From: Anita Gardner
Sent: 02 October 2013 13:29
To: Jason Hales
Subject: RE: Planning Consultation on: LU/241/13/L

A NEW KITCHEN EXTENSION
 AT • TODDINGTON HOUSE •
 LITTLEHAMPTON. ©. 10th MAY 2013
 FOR • MR & MRS M. WAROM • DRWG. N° 740/P03-

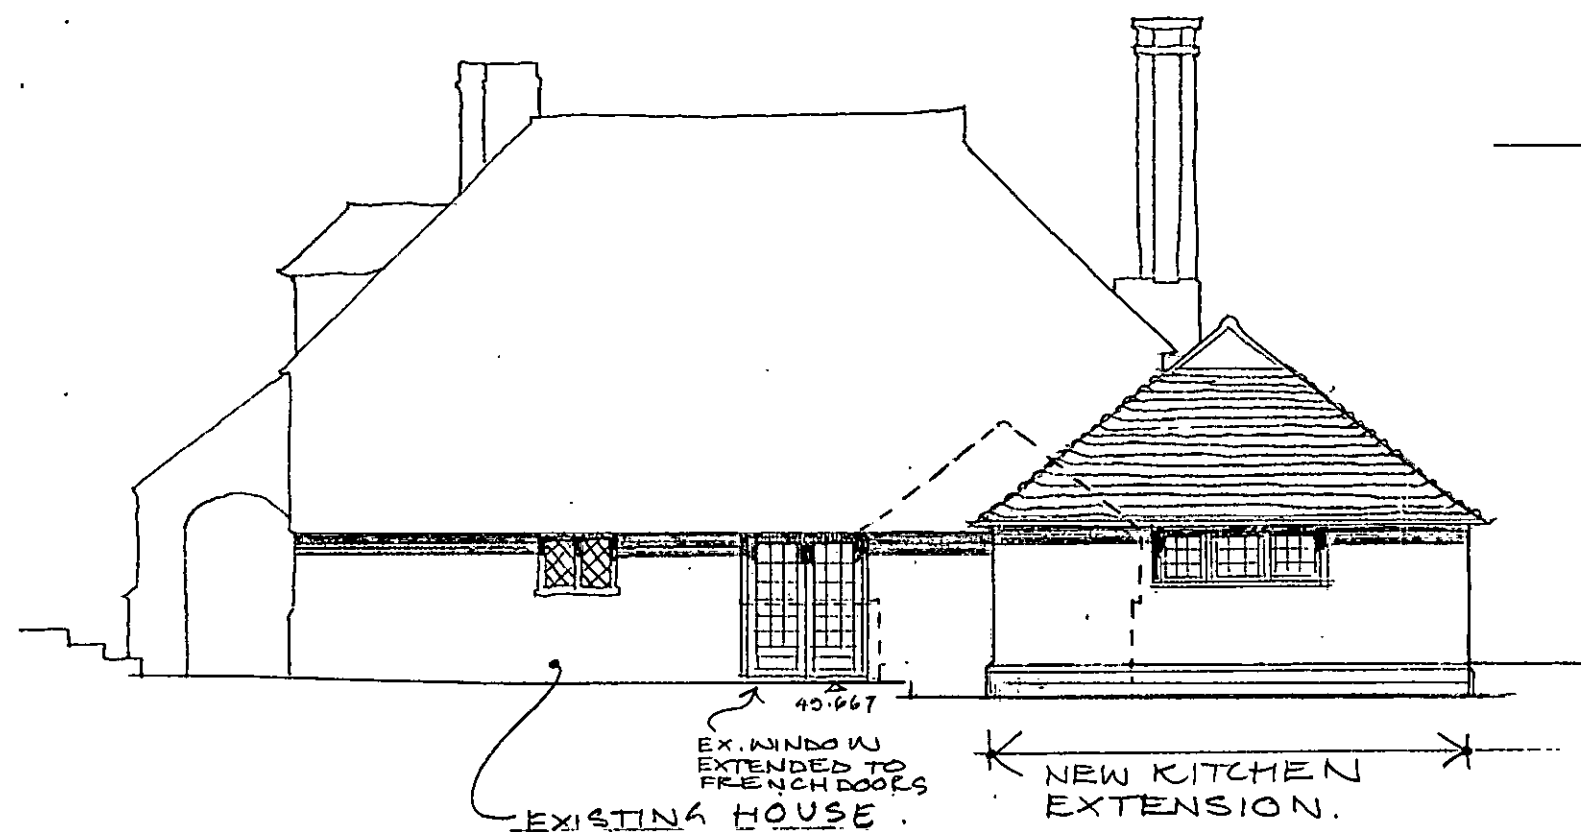
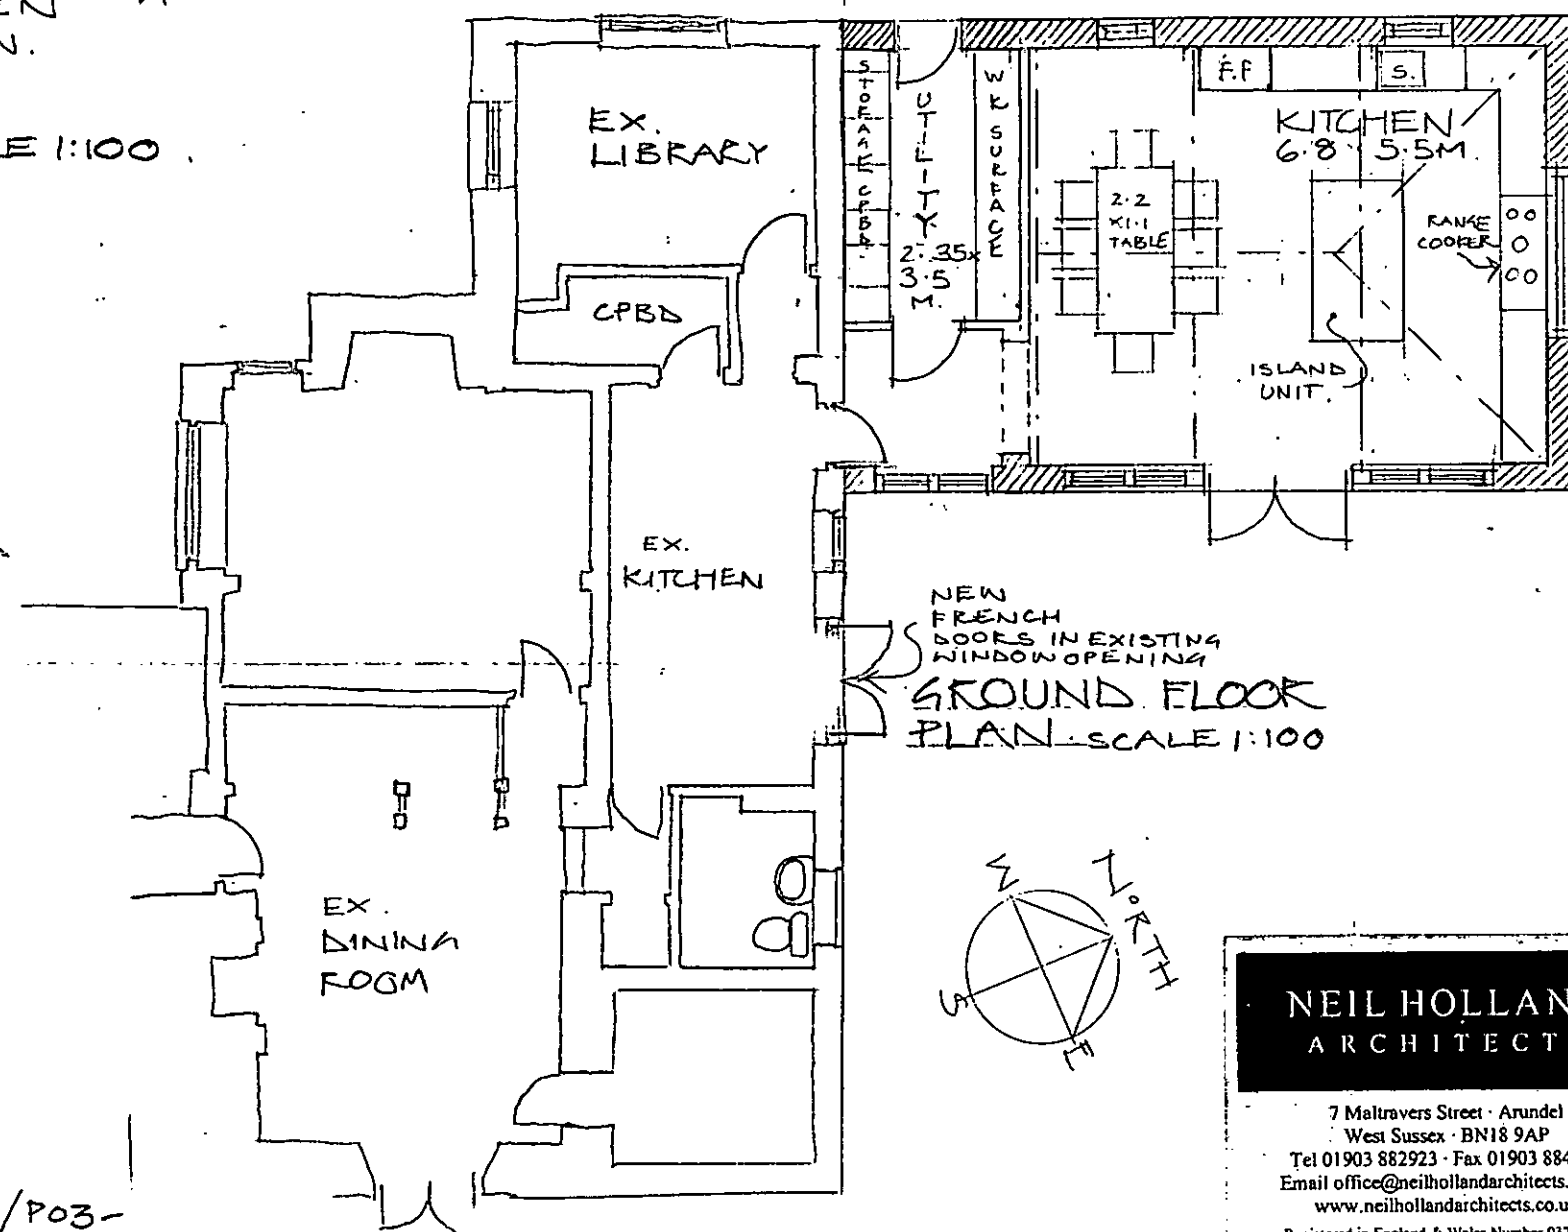
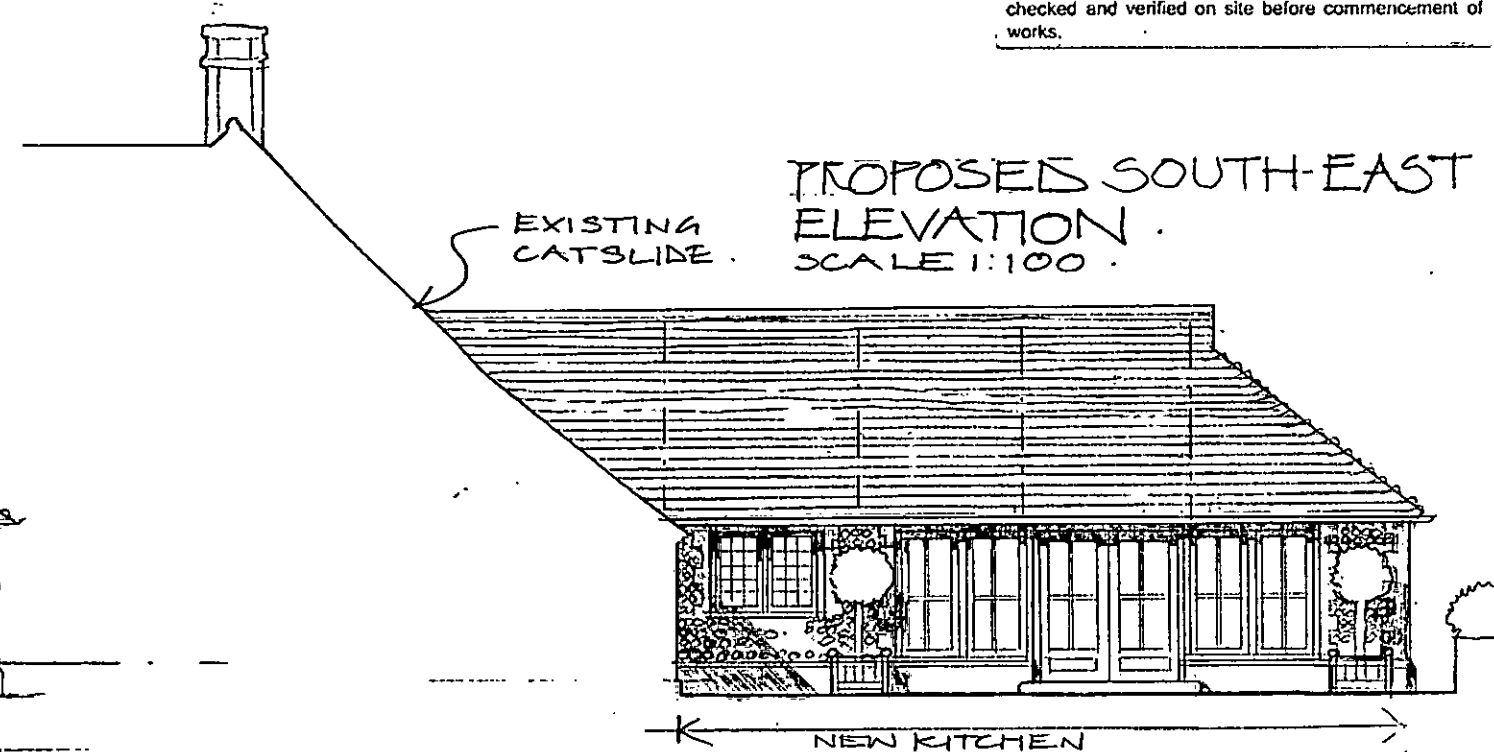
Dear Mr Hales,
I discussed your proposal further with Dr Wightman yesterday. It is not considered that adequate justification for the size of extension proposed exists and therefore the applications will be recommended for refusal.
Regards
Anita Gardner

Ian Wightman visits the Council offices on a Wednesday, so he will not be here until next week. I will forward your comments to him, but he will not be in a position to provide a response until the middle of next week. A restriction in the length of the extension in addition to justification is being sought so it is likely your client will need to consider this possibility further.

Dear Jason,
I attach Ian Wrightman's comments for your information.
Accordingly, without prejudice, I would welcome receipt of amended plans reducing the length of the extension by approx. 2.5 metres. It would also be useful if the extract of the proposed ground floor plan could indicate the proposed uses of the ex. dining room, kitchen and library.

Reading through his comments we indeed would like the opportunity to substantiate the scale of the extension in terms of the accommodation in respect to the proposed utility.

The need for a proper utility room is largely borne out of the fact that the client is looking an existing, much used large larder and kitchen equipment room store. The space for this can again be hidden away in its own space if housed in the proposed utility room.

During the design process we did look into putting the new utility room in the existing house -- the library and existing kitchen, but these two spaces are too good and important to the existing house design complexity to maintain the integrity for the following reasons:-

The library has rather wonderful panelled walls with bespoke bookcases and complex ceiling structure. Books are a very important element of the home and this room is a wonderful feature of the house. This is highly valued and will continue to be used as the library and music room. This makes the library an unsuitable option.

The existing kitchen space is to become the back hall and is the only throughfare through the main house to the new kitchen extension. Making the space into a utility room would be an undesirable and impractically designed feature and would compromise the current, composite design features of the house and therefore would be un-acceptable; the client understandably did not wish to fill it with utility units.

Rooms such as the second bedroom are already being used as other rooms for ironing etc and combined with the above reasons, we believed this substantiated the need to position the new utility in the new extension out of the existing house.
